August 1, 2024

RE: Responses to Comments – Traffic Impact Study (E19D025C2)
Dutch Bros Coffee (NM0504)
7330 San Antonio Drive Northeast, Albuquerque, New Mexico
City File No. E19D025C2 / Our Job No. 23204

Title: PROPOSED OFFSITE IMPROVEMENTS  
7330 SAN ANTONIO DR NE  
ALBUQUERQUE, NM 87109

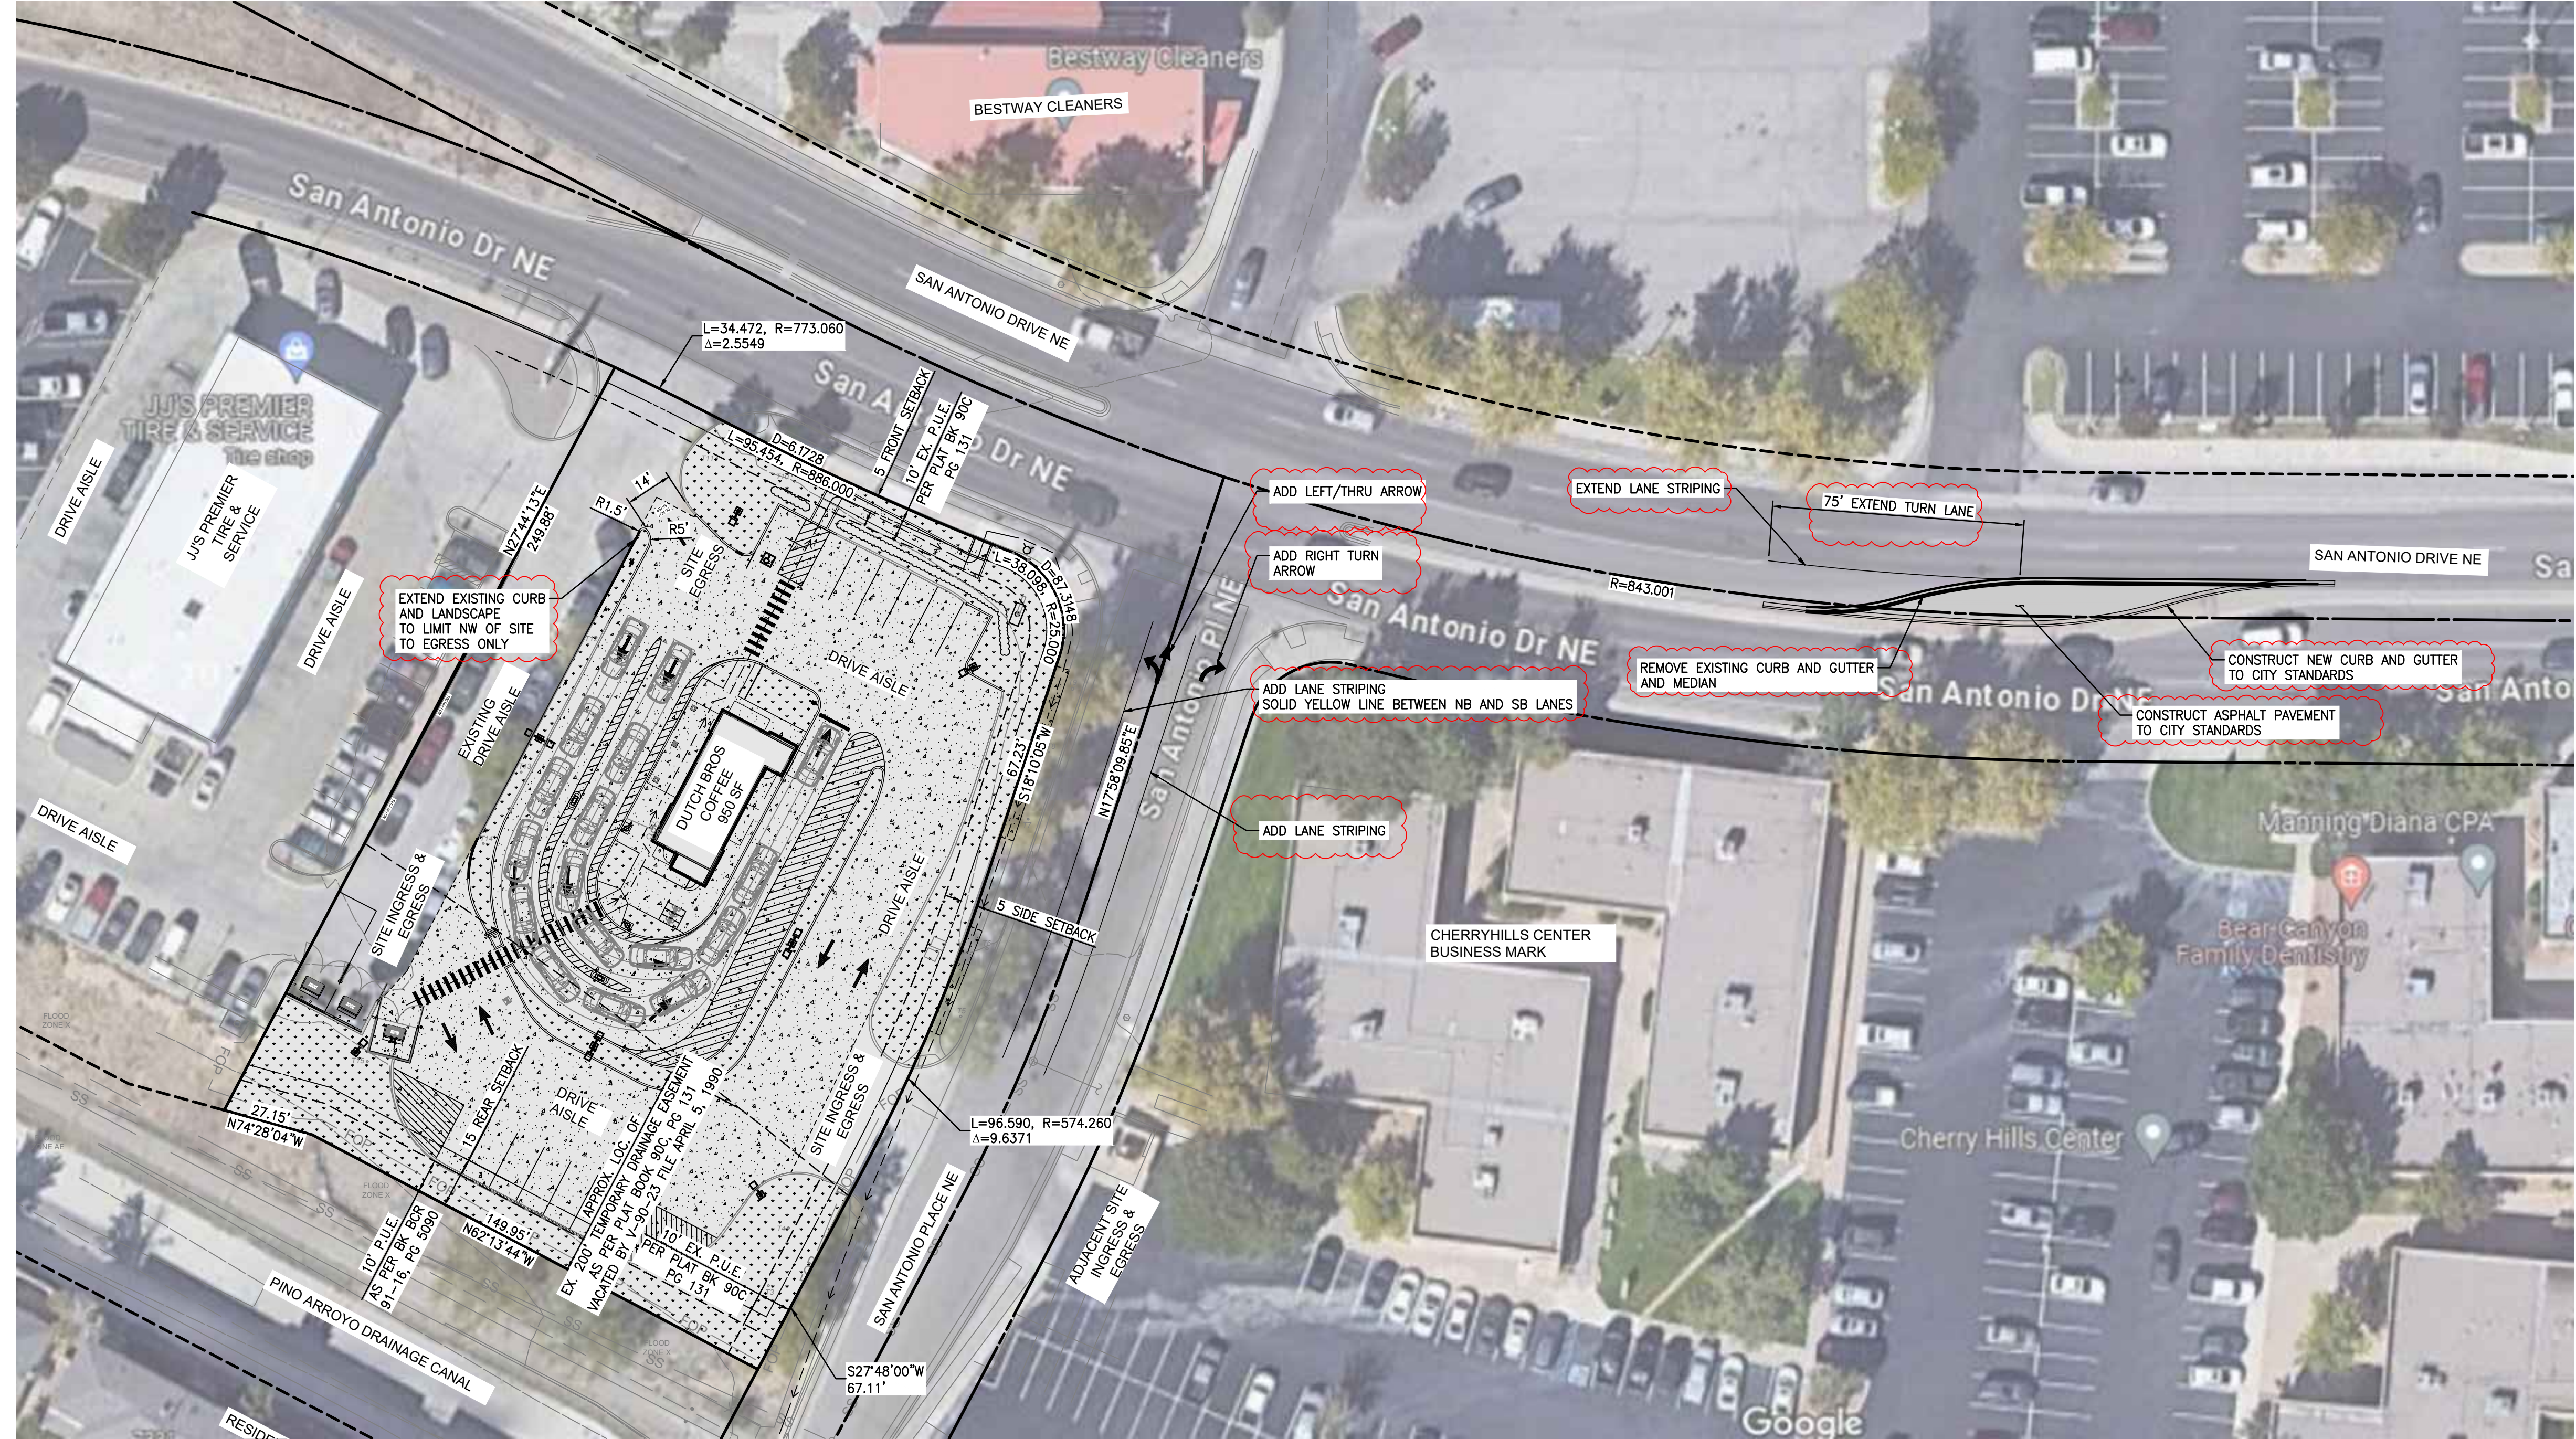
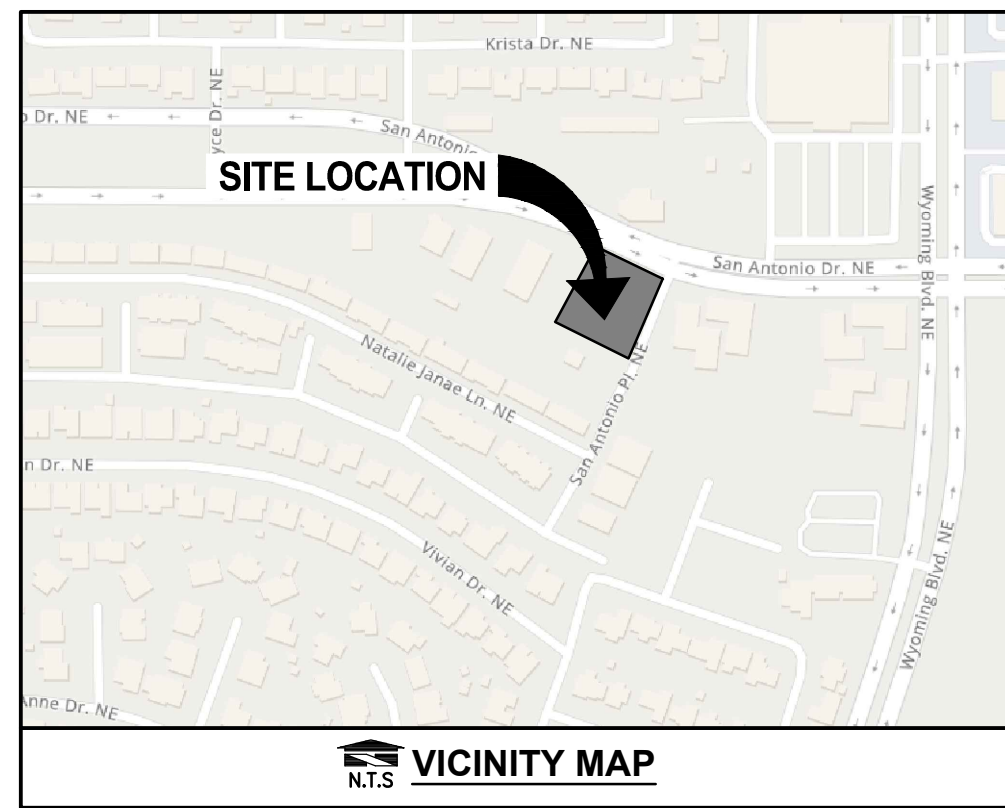
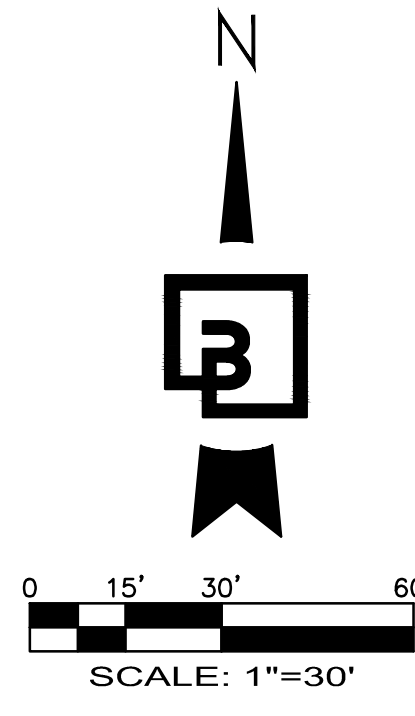
2. *To minimize delays for drivers turning right onto eastbound Wyoming and provide lane clarification for the left-thru movement and right turn movement, construct pavement markings on San Antonio Pl at the northbound approach to San Antonio Dr.*

4. *The existing westbound left-turn lane at the San Antonio Place NE/ San Antonio Dr NE intersection should be extended as far as it can be extended to support the additional traffic making this movement. It appears approximately 75' of storage can be added.*

Response: The traffic report has been updated. Appendix A in the report depicts improvements requested.

Response: The traffic report has been updated. Appendix A in the report depicts improvements requested.
